Our Ref: 24/01051/FUL  
Your Ref: Single storey extension to an...

**South Cambridgeshire District Council**  
**Application for Planning Permission**

Proposal: Proposed single-storey extension to an existing school building.

Site address: Aurora Meldreth Manor School Fenny Lane Meldreth Cambridgeshire

dwg no:
P01

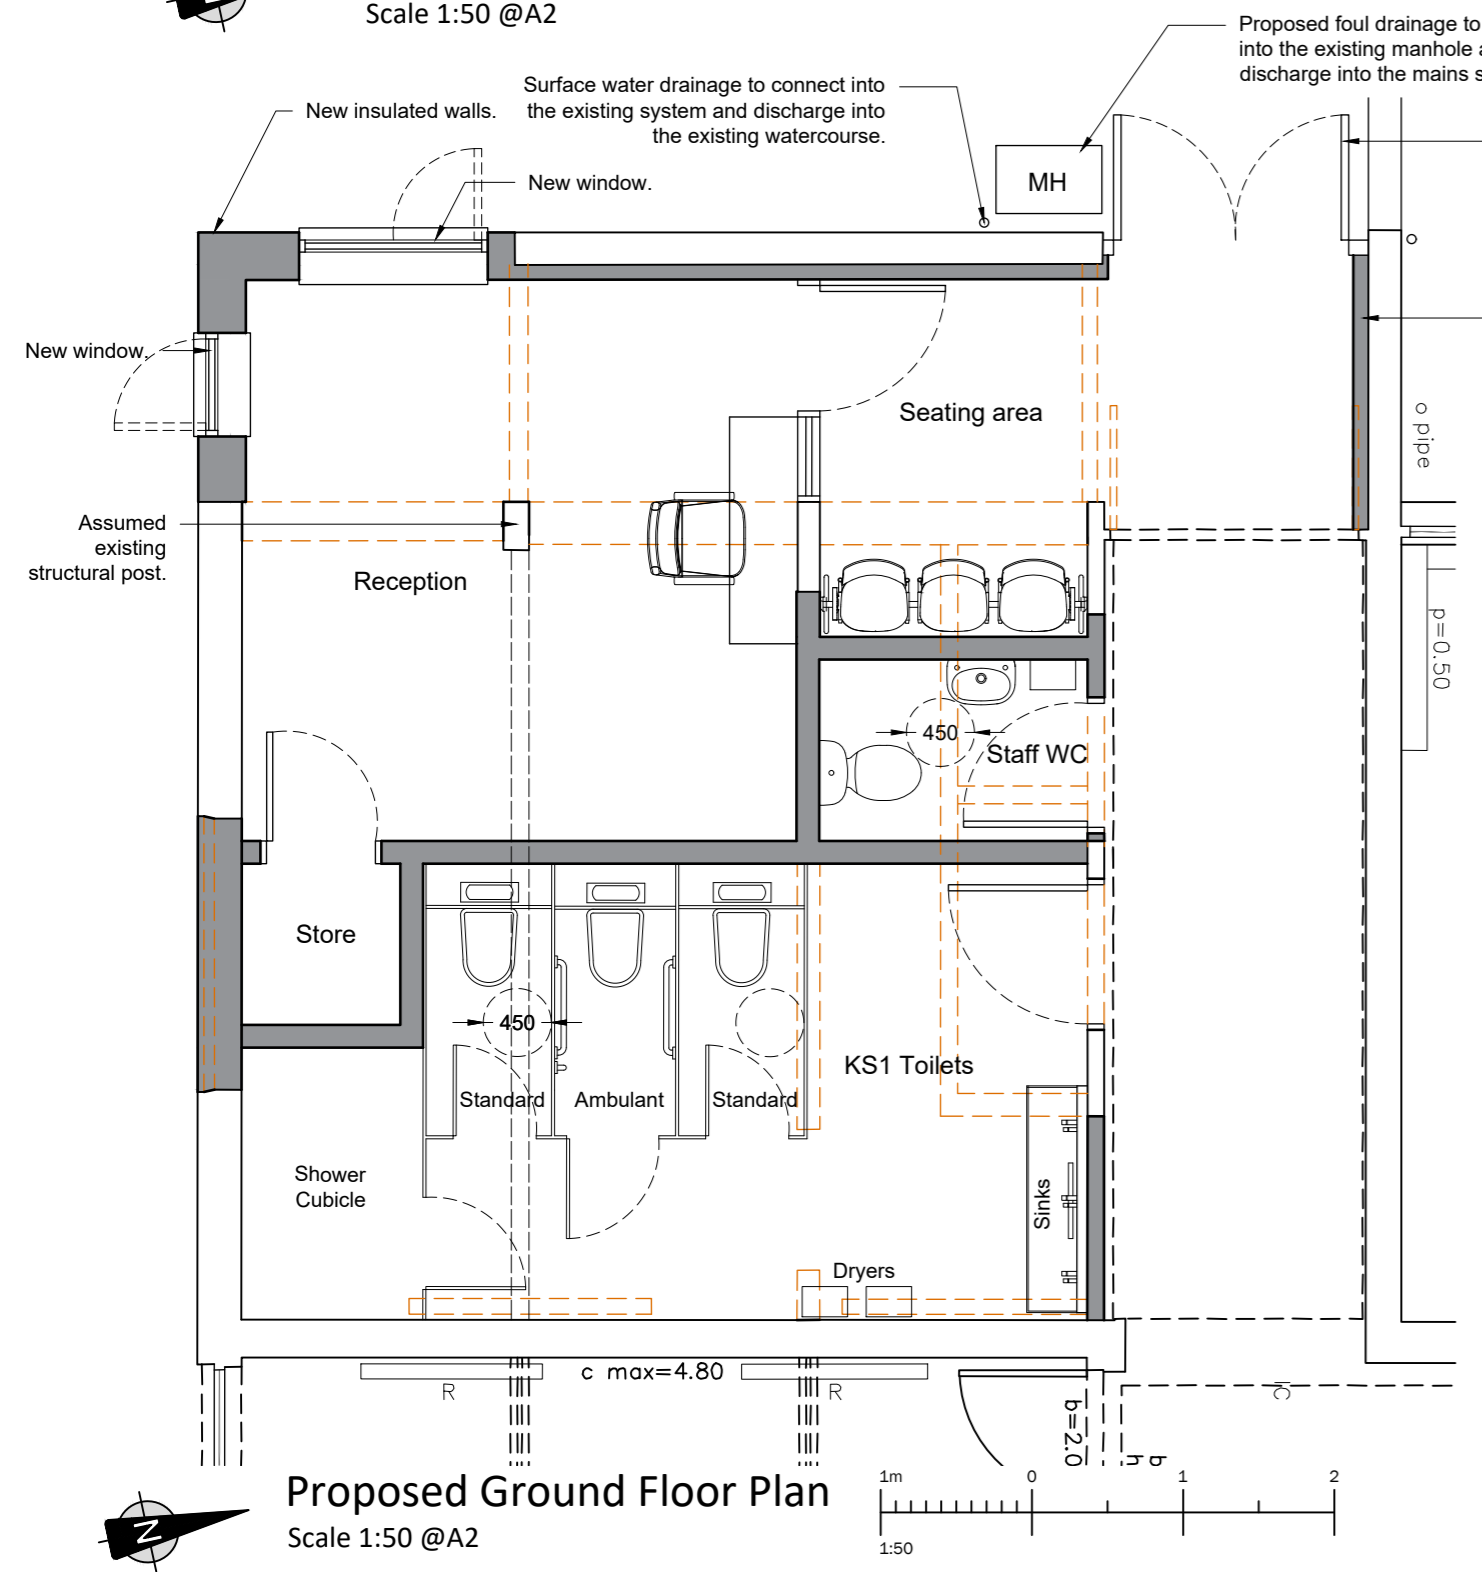
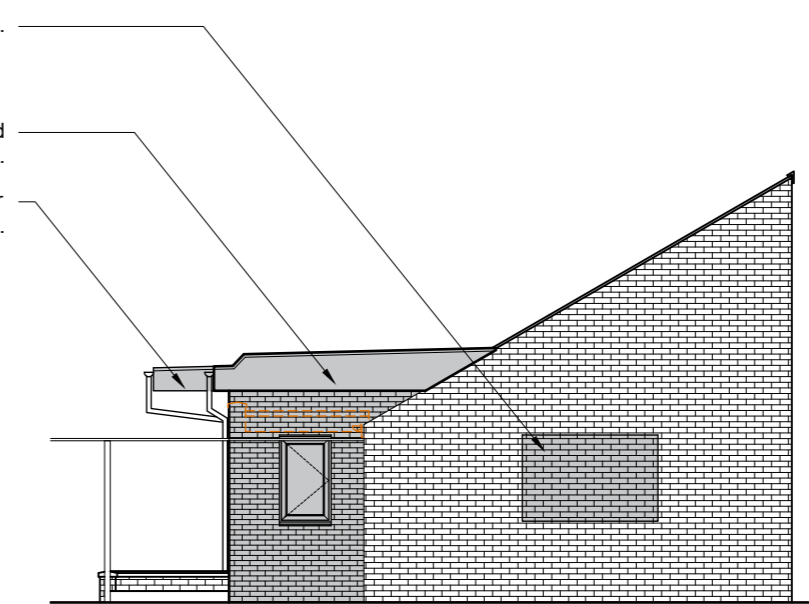
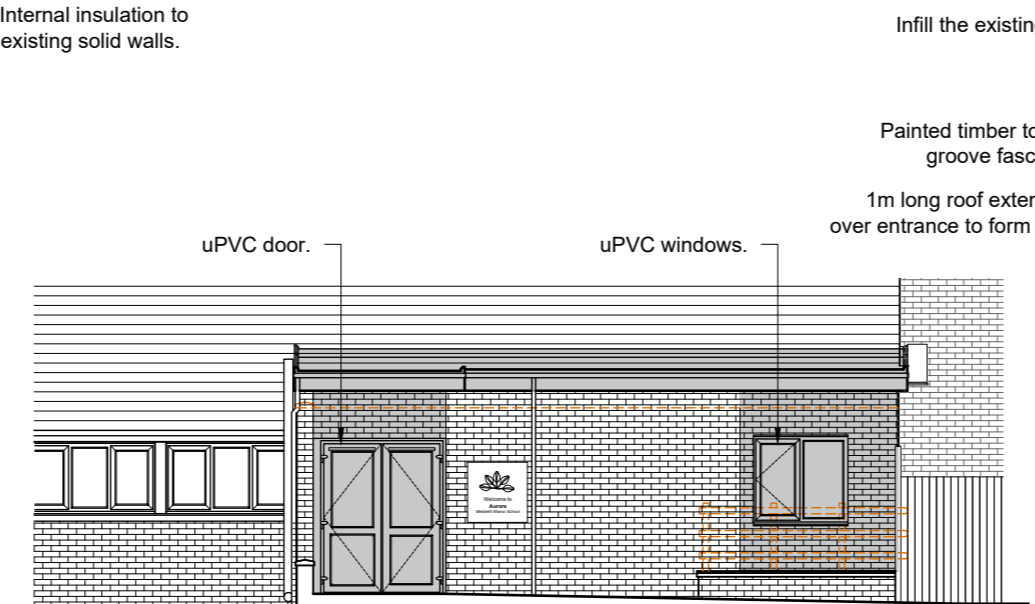
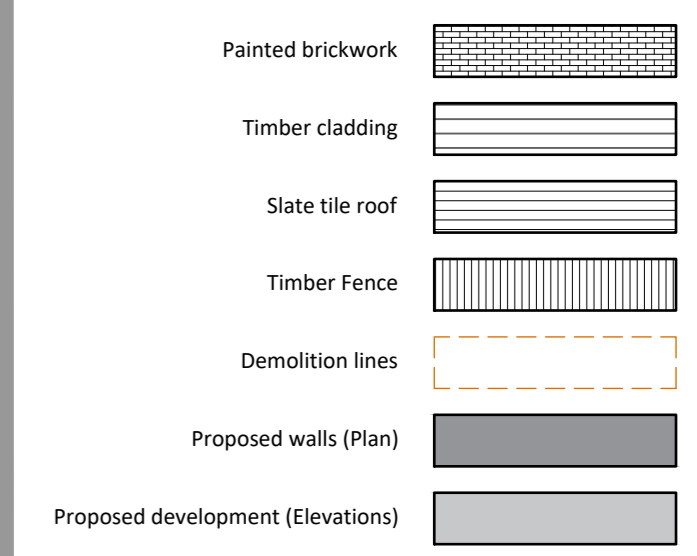
1. Please provide a location plan. Please ensure this is at a scale of 1:1250/1:2500 with 2 named roads, the site outlined in red and any adjoining land owned by the applicant outlined in blue, access to site, visibility splays, landscaping and car parking & open areas around buildings.

Please amend the location plan to extend the red outline to include access to and from the public highway in accordance with local validation requirements. Please forward this to the below address and do not resubmit via portal.
